M25 junction 10/A3 Wisley interchange TR010030 9.5 DCO Application Errata Schedule

9.5 DCO APPLICATION ERRATA SCHEDULE

Regulation Number:	Regulation 5(2)(q)
Planning Inspectorate Scheme Reference	TR010030
Application Document Reference	TR010030/EXAM/9.5
Author:	M25 junction 10/A3 Wisley interchange project team, Highways England and Atkins

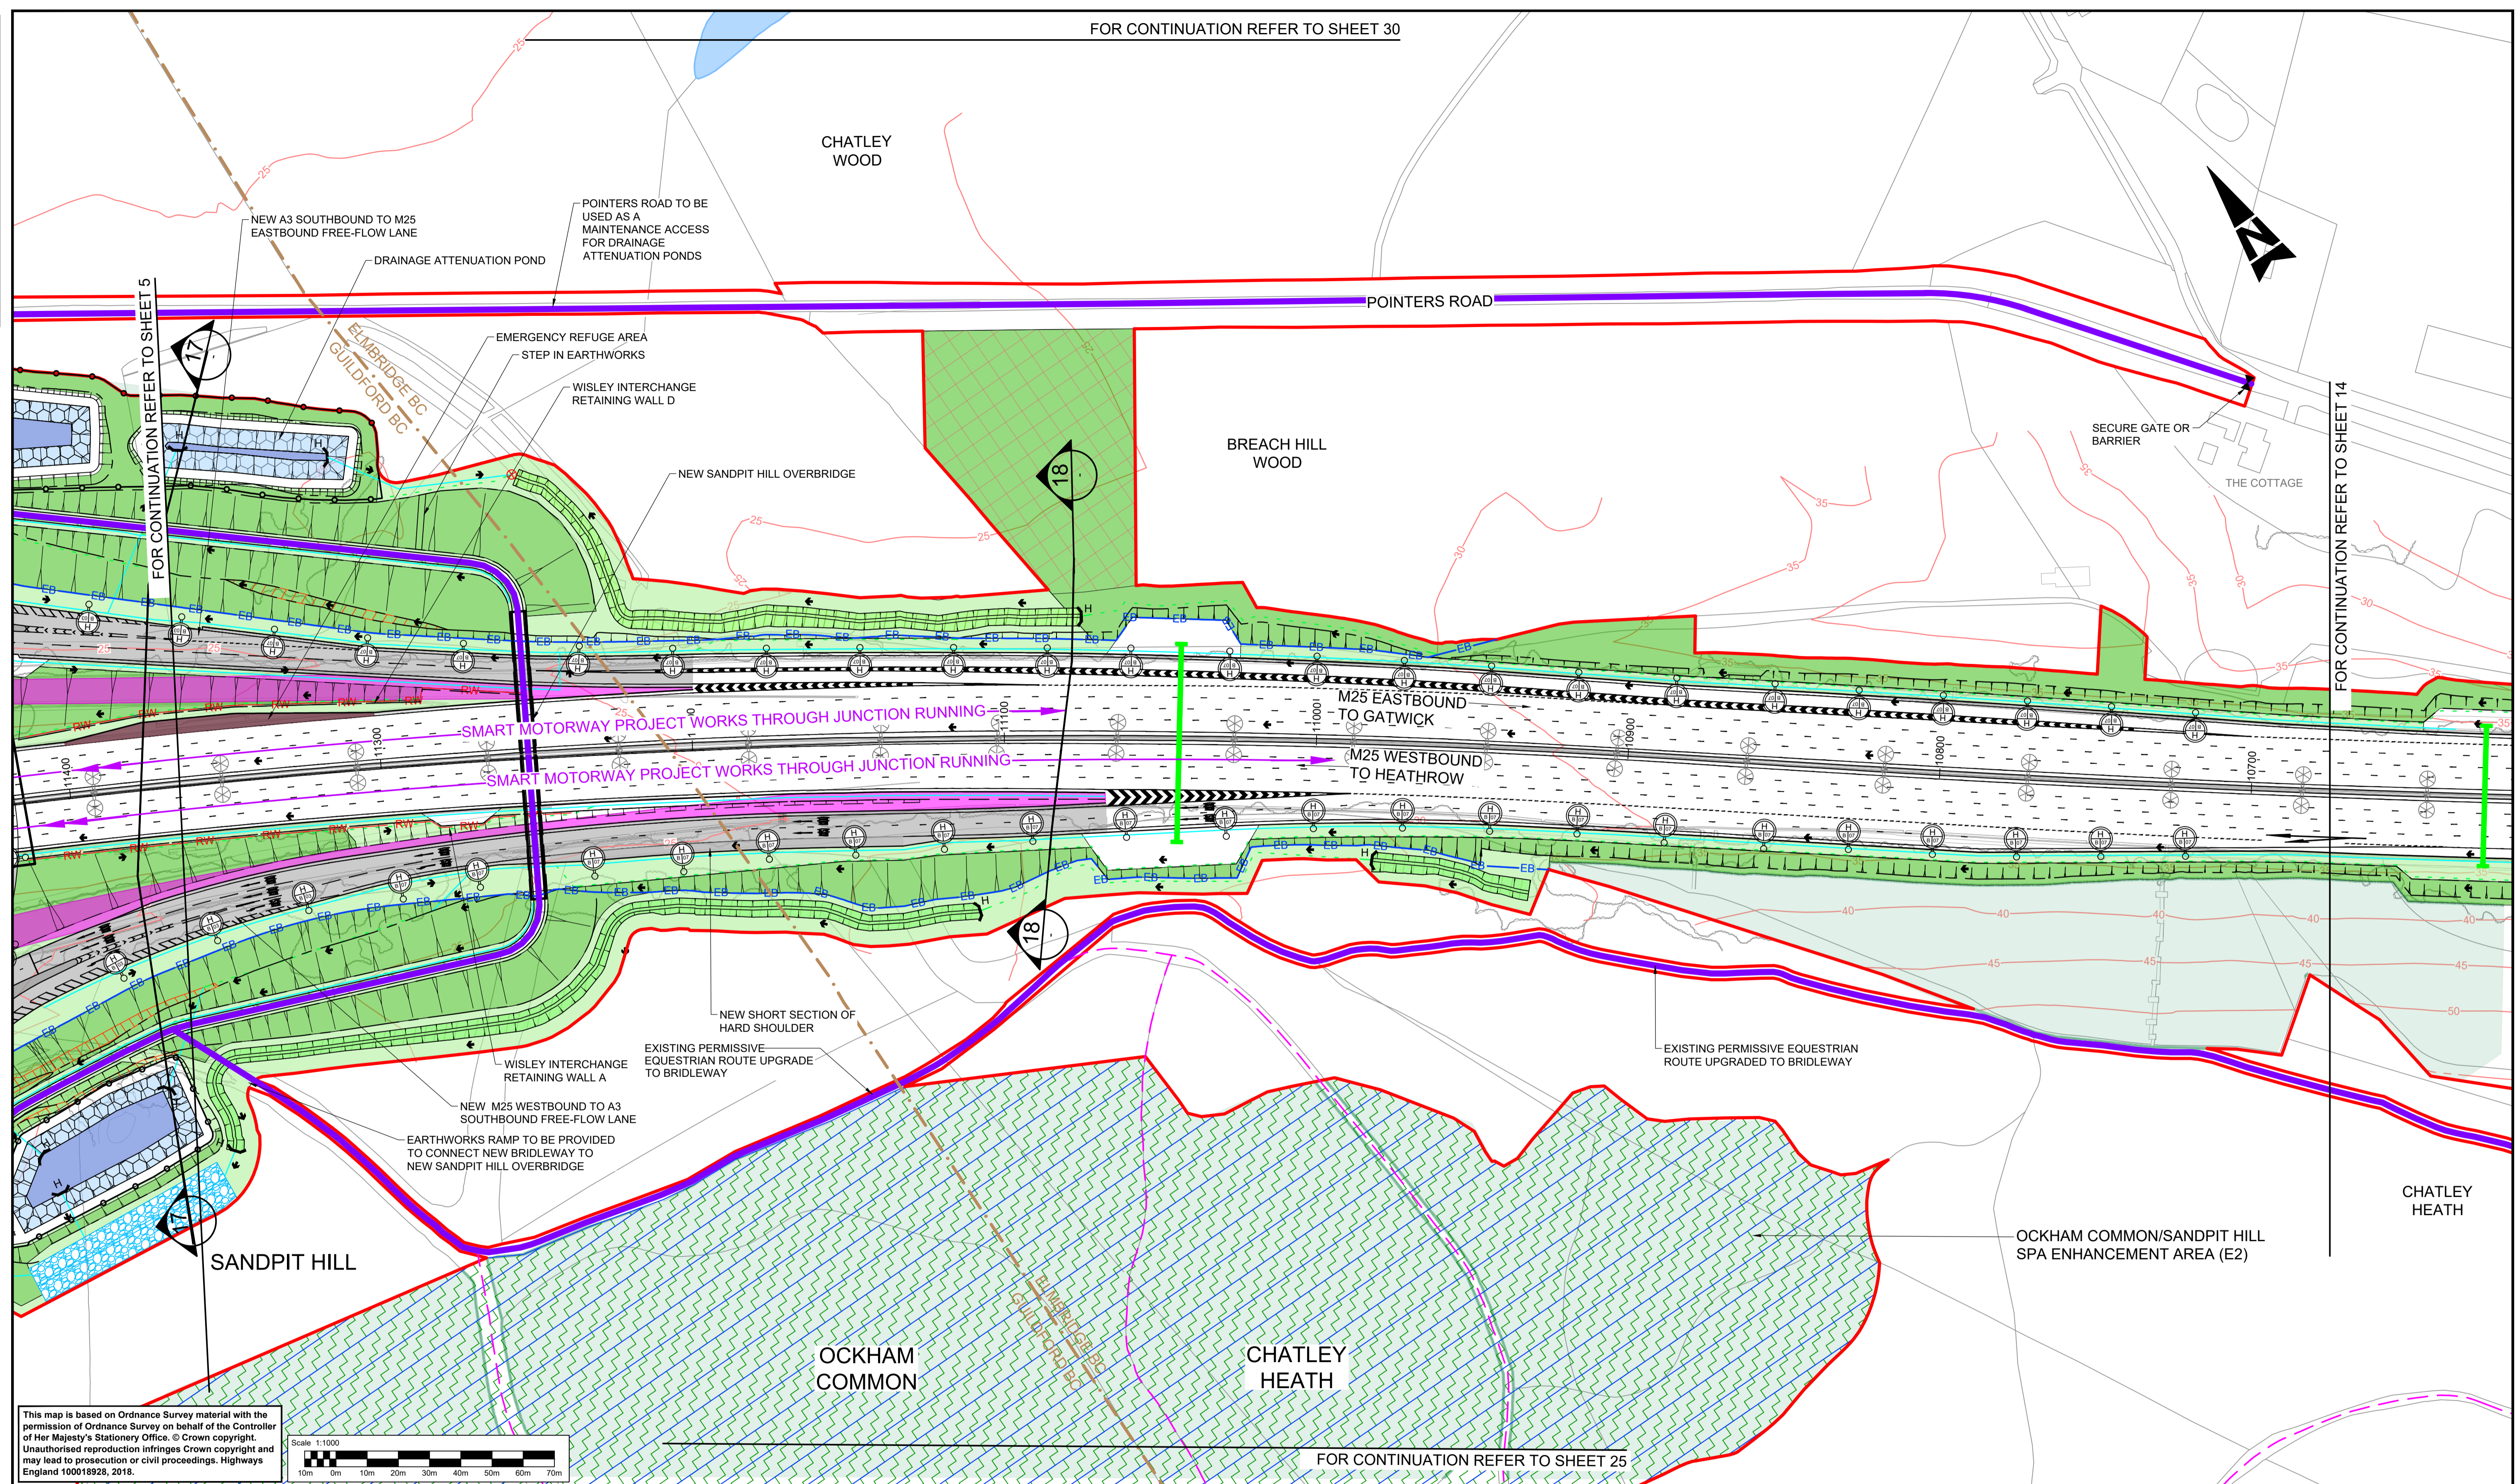
APP-012	2.8 Scheme Layout Plans (Sheets 1-10 of 31)	Sheet 7 of 31	The label reading “New B365 Seven Hills Road extension” is incorrect and should be changed.	New private means of access and bridleway.
APP-012	2.8 Scheme Layout Plans (Sheets 1-10 of 31)	Sheet 7 of 31	The label reading “New Red Hill substitute access” is to be removed.	Remove label.
APP-012	2.8 Scheme Layout Plans (Sheets 1-10 of 31)	Sheet 7 of 31	The markings which identify the restoration of construction compounds and proposed open grassland around the former San Domenico Hotel are incorrect.	No change to text. Redraw the marking showing the correct area of restoration and open grassland around the San Domenico site.

**SHEET 26 OF 31**

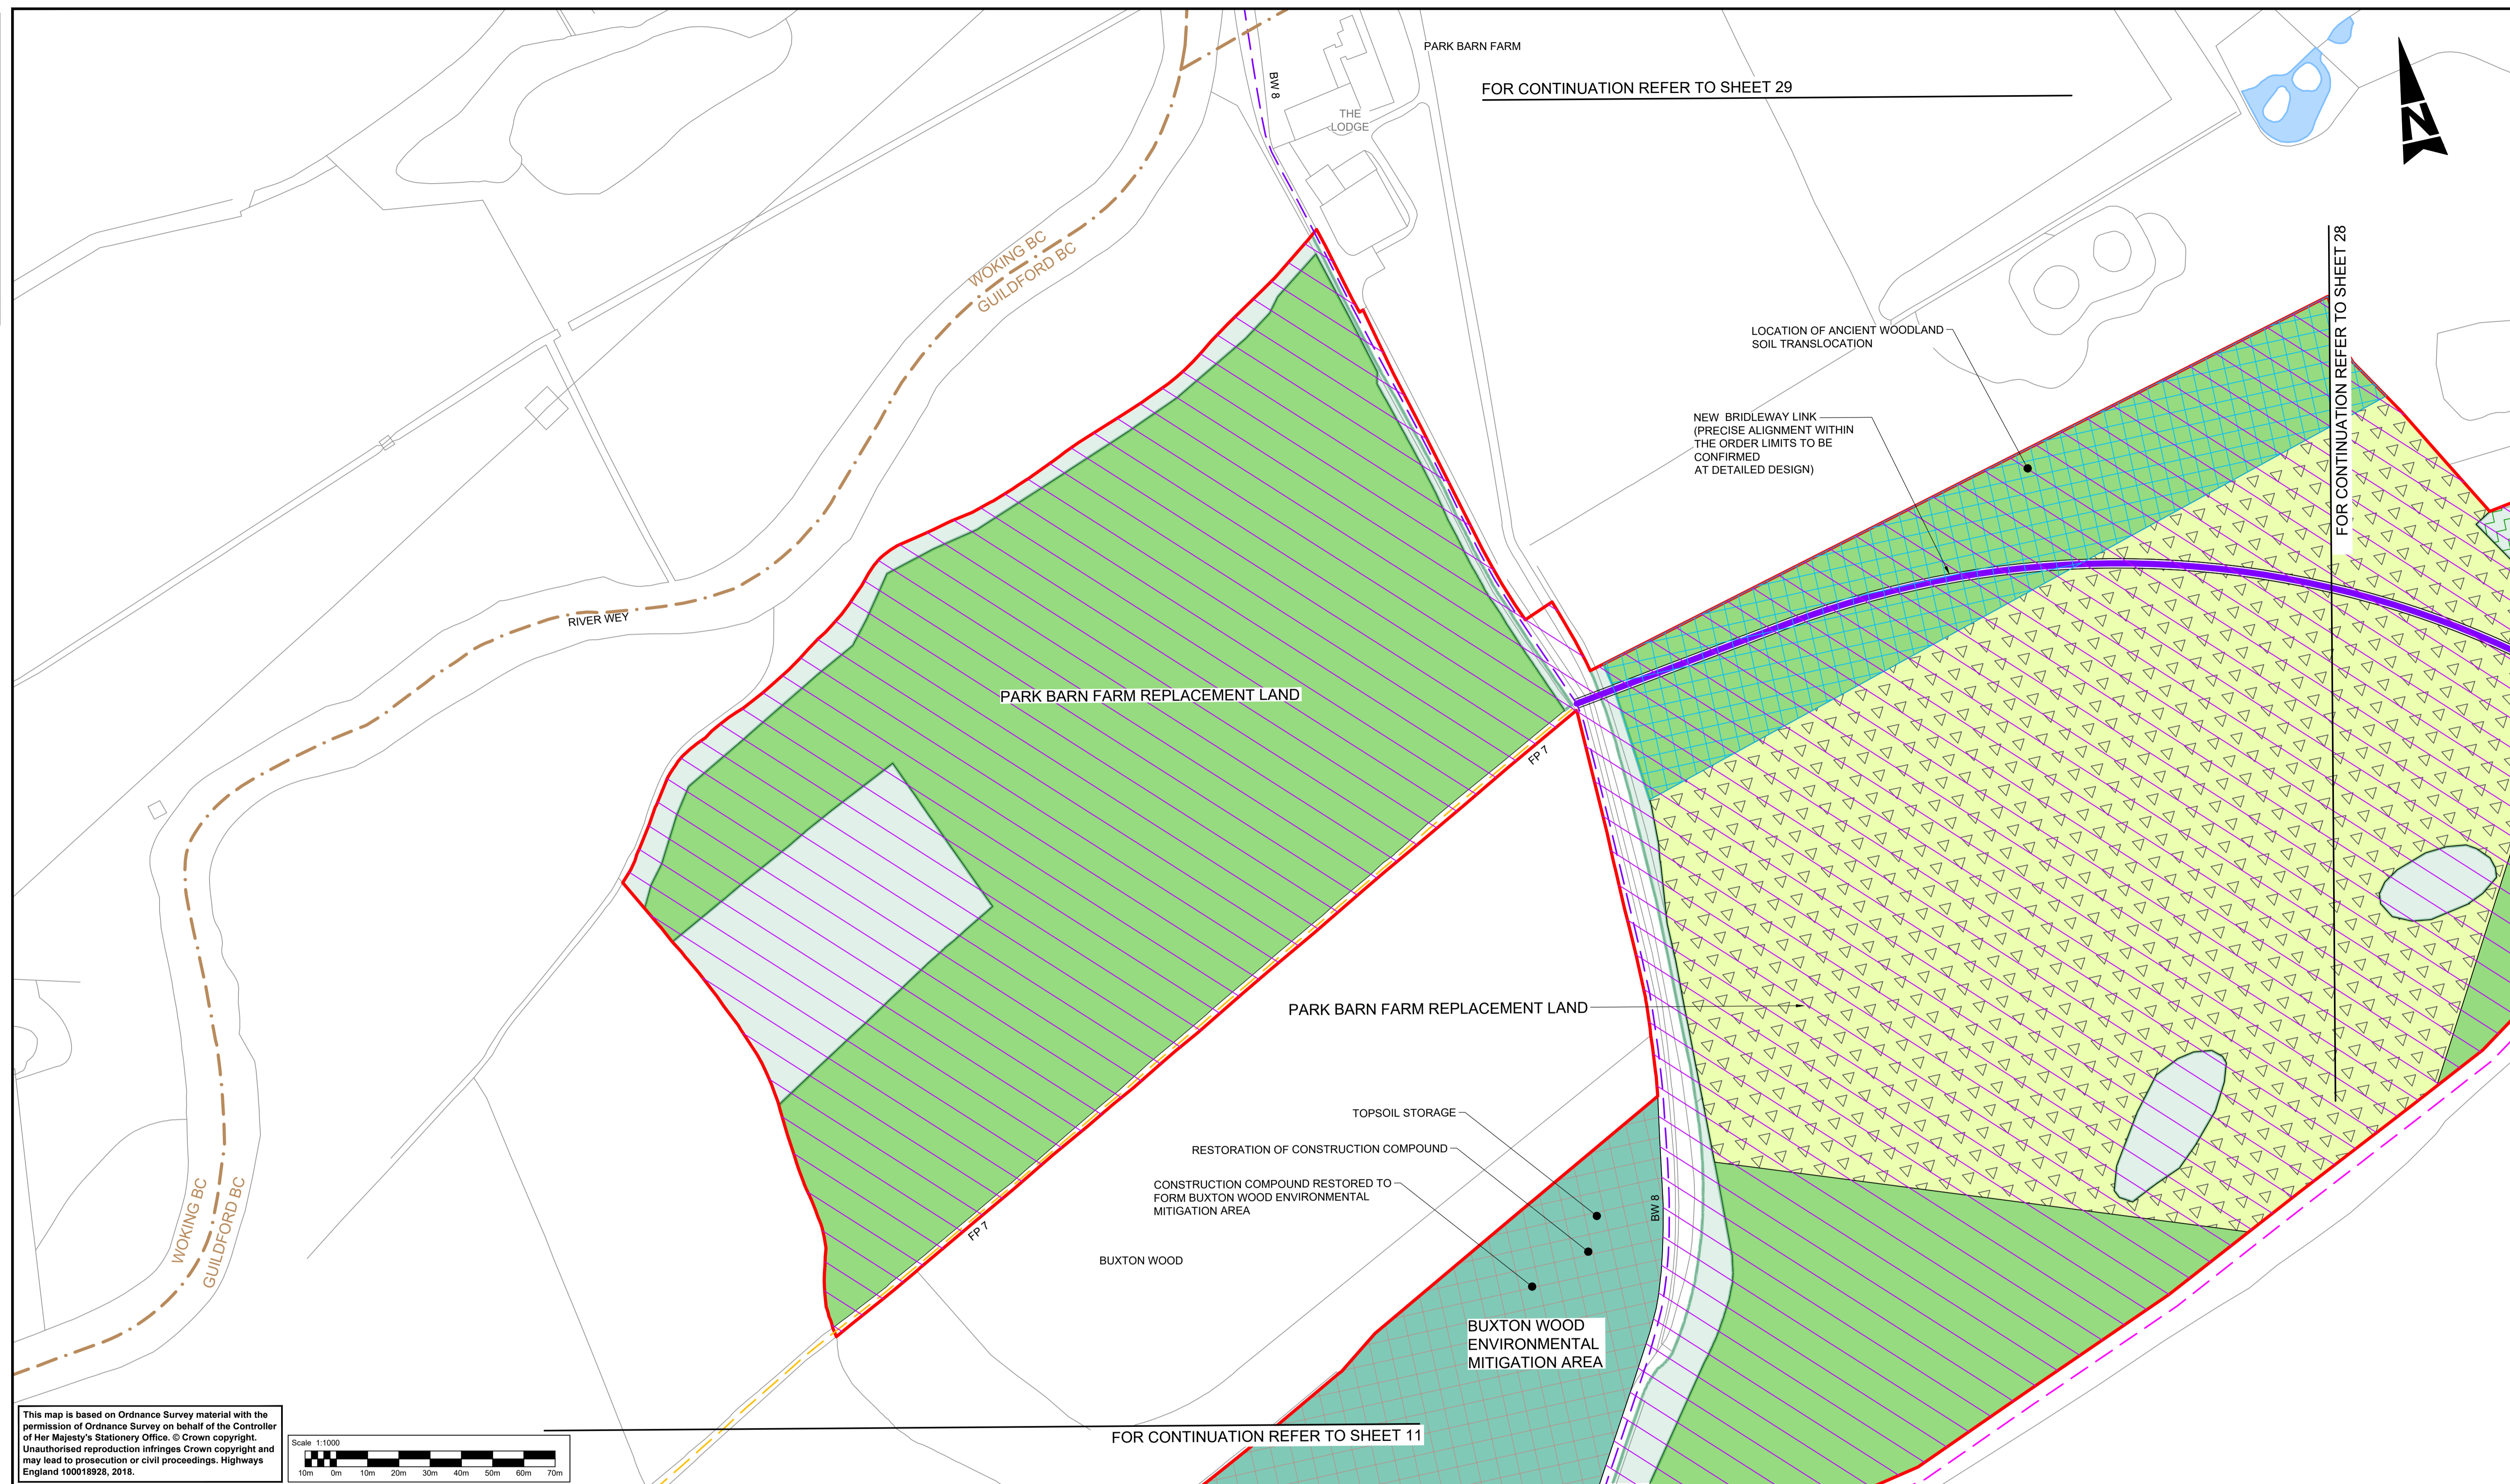
APP-013	2.8 Scheme Layout Plans (Sheets 11-31 of 31)	Sheet 23 of 31	Incorrect label reading "Bridleway link to Elm Lane improvement."	Rename "Bridleway link along the closed part of Elm Lane"
APP-013	2.8 Scheme Layout Plans (Sheets 11-31 of 31)	Sheet 26 of 31	Incorrect arrow for the "New footpath join to Bridleway 18" is pointing at the proposed bridleway and not, the footpath	No change to text. Move the arrow point to the proposed footpath.
APP-013	2.8 Scheme Layout Plans (Sheets 11-31 of 31)	Sheet 27 of 31	Incorrect label reading "Buxton wood replacement land" to be removed.	Remove label and arrow.
